From: Planning
Subject: FW: 3.24.566 - 8 Carter Fold Mellor
Attachments: 002 - Proposed Plan - Rev B.pdf

From: Akhtar, Tahira <
Sent: Monday, September 2, 2024 9:16 AM
To: Lucy Walker <
Cc: Planning <planning@ribblevalley.gov.uk>
Subject: FW: 3.24.566 - 8 Carter Fold Mellor

I have recently received the attached amended plan from the agent detailing 2no. on-site parking spaces to be provided at the front of the dwelling.

Proposed Site Plan  
Scale (1:500)

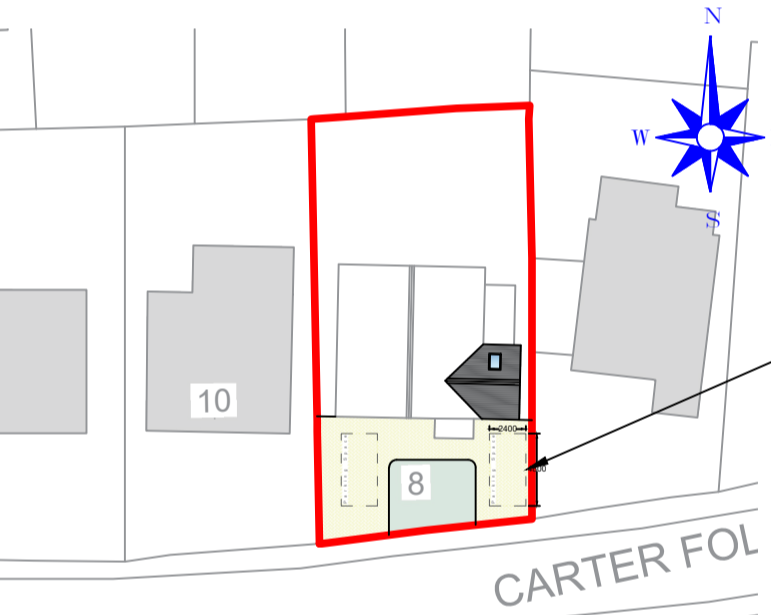
Please could you confirm whether this is acceptable from a highway perspective?

Further to the attached proposed plan submitted, yes this is acceptable, as the existing drive and parking spaces are to be retained. Therefore, parking standards requirements are being met for this proposal. No highway objection.
